Application Reference: 2025/1027

Site Address: 2 Greystones Avenue, Worsbrough, Barnsley, S70 5JQ

Introduction: Erection of single storey side extension to dwelling.

Drawing Title **PROPOSED PLANS**

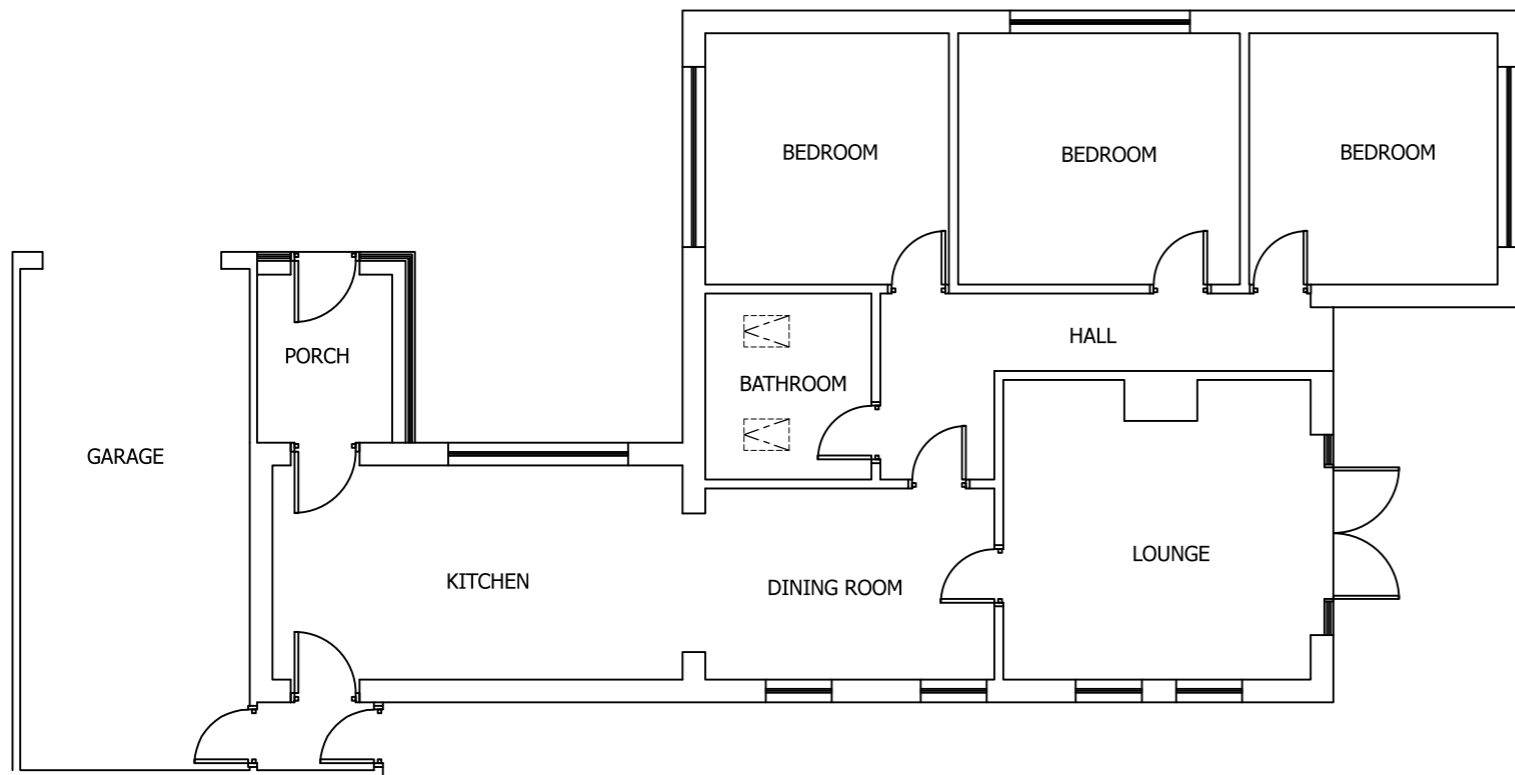
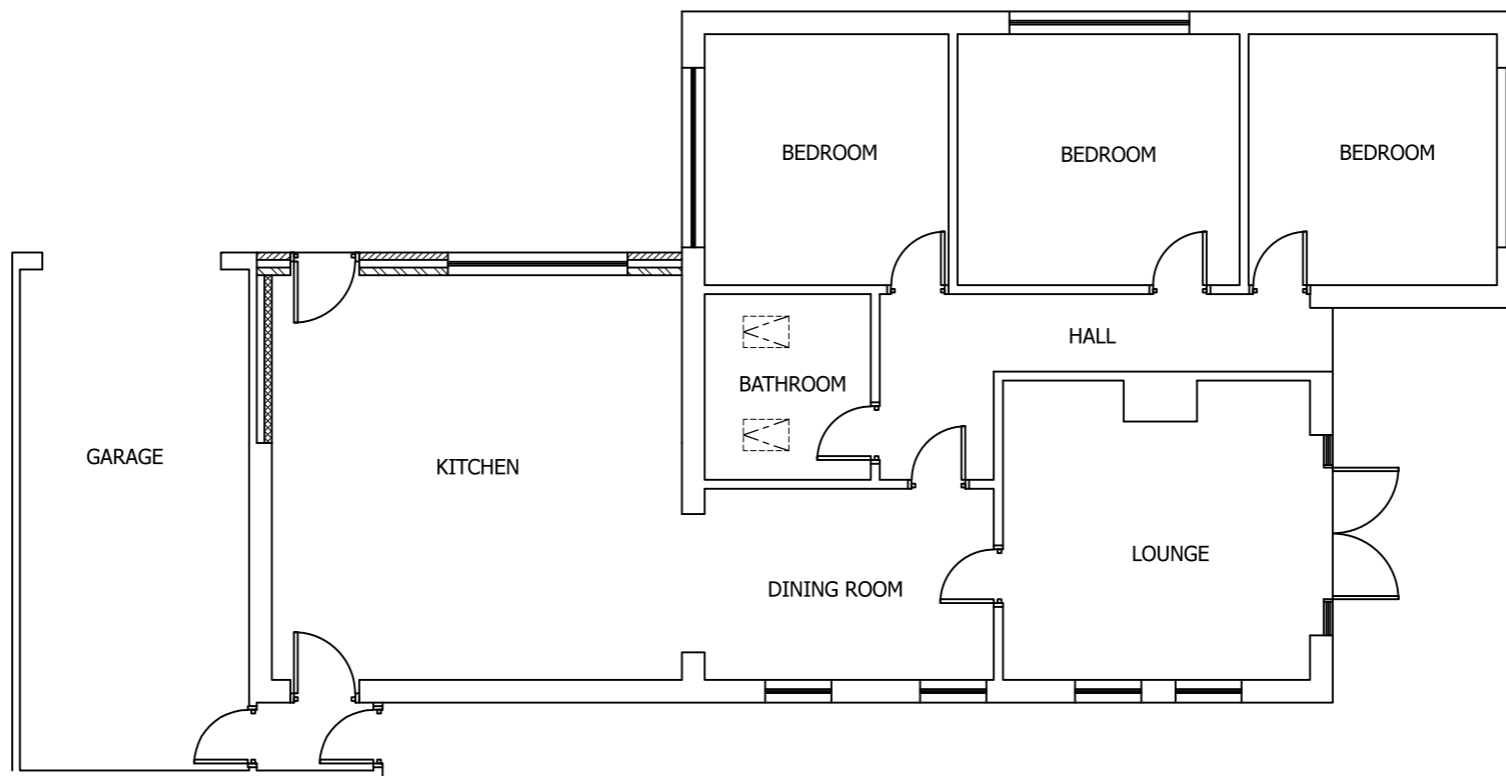
The extension would be erected to the rear of the existing dwelling and the side of the existing rear extension. The proposal would essentially be an infill extension between the rear elevation of the existing dwelling, the side of the existing rear extension and the existing flat roofed garage. The proposal provides a modest projection of approximately 2.5 metres which would not project further than the existing front elevation of the garage facing the highway. The proposal would not exceed two thirds the width of the original dwelling or be more than half the distance between the existing dwelling and the boundary.

The proposed extension would be screened to the west, north and south by the existing extension, garage and dwelling. The proposal would therefore not be impactful on neighbours to the north and west of the site. The proposal would result in the removal of the pitched roof of the existing extension. The proposal would therefore have a reduced impact on neighbours to the north and west. The proposal would project further to the east than the existing rear extension, however, would not project further to the east than the existing dwelling. The proposal would therefore have no greater dominant impact than the existing dwelling. The proposal would be partially screened to the east by boundary treatment reducing the opportunity for overlooking.

Drawing Title  
**PROPOSED ELEVATIONS**

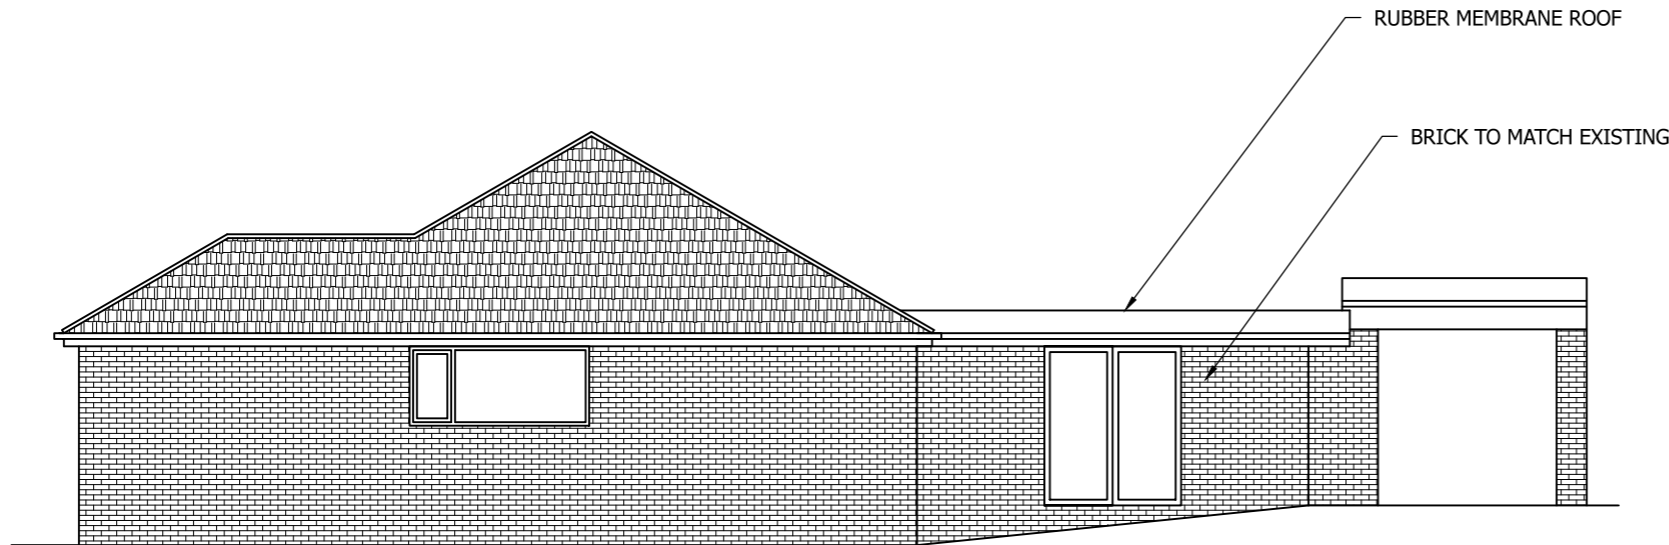
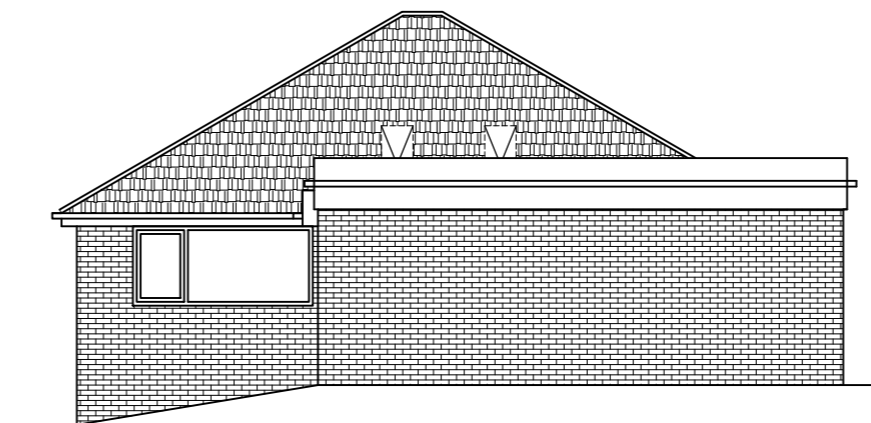
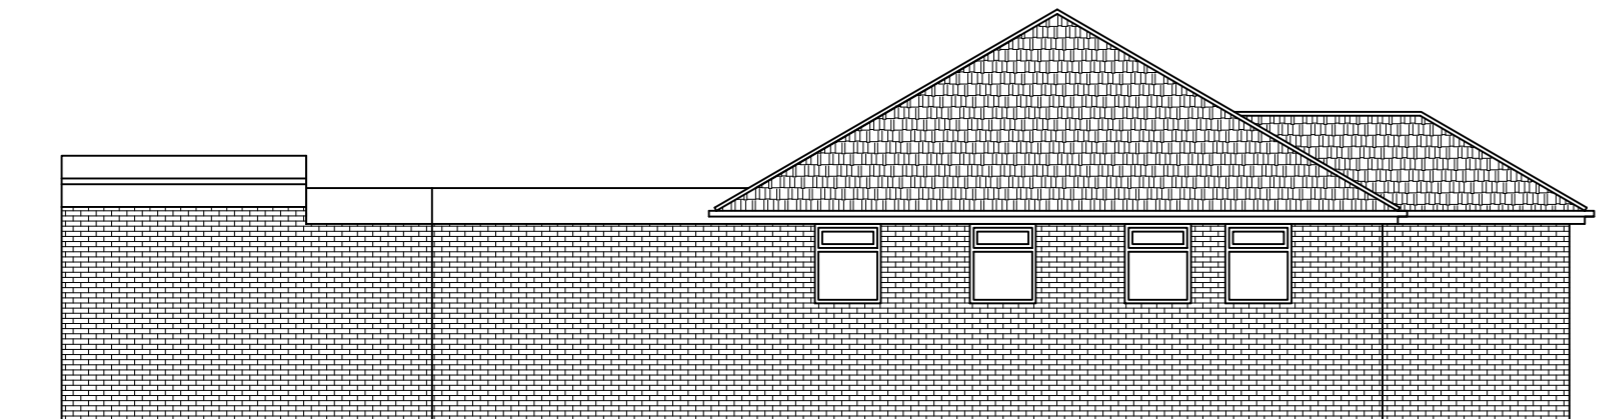
Although a flat roof would not be preferred, given the site already provides a flat roofed garage and porch, the use of a flat roof on this occasion would not detrimentally detract from the character of the site. It is also acknowledged there are other flat roofed garages and dormers within the street scene. Furthermore, although the extension is considered a side extension, the proposal would be screened from view by significant boundary treatment and is to the rear of the dwelling. The proposal would therefore only be seen on fleeting occasions when passing the site.

The proposed east facing glazing is detailed centrally to the proposal and matches existing fenestration on the dwelling. Matching brickwork has been detailed ensuring the proposal remains in keeping with the site and street scene.

Amendments were requested from the application to provide a pitched roof form however these were not provided as the pitched roof form would result in the loss of the rooflights servicing the bathroom.
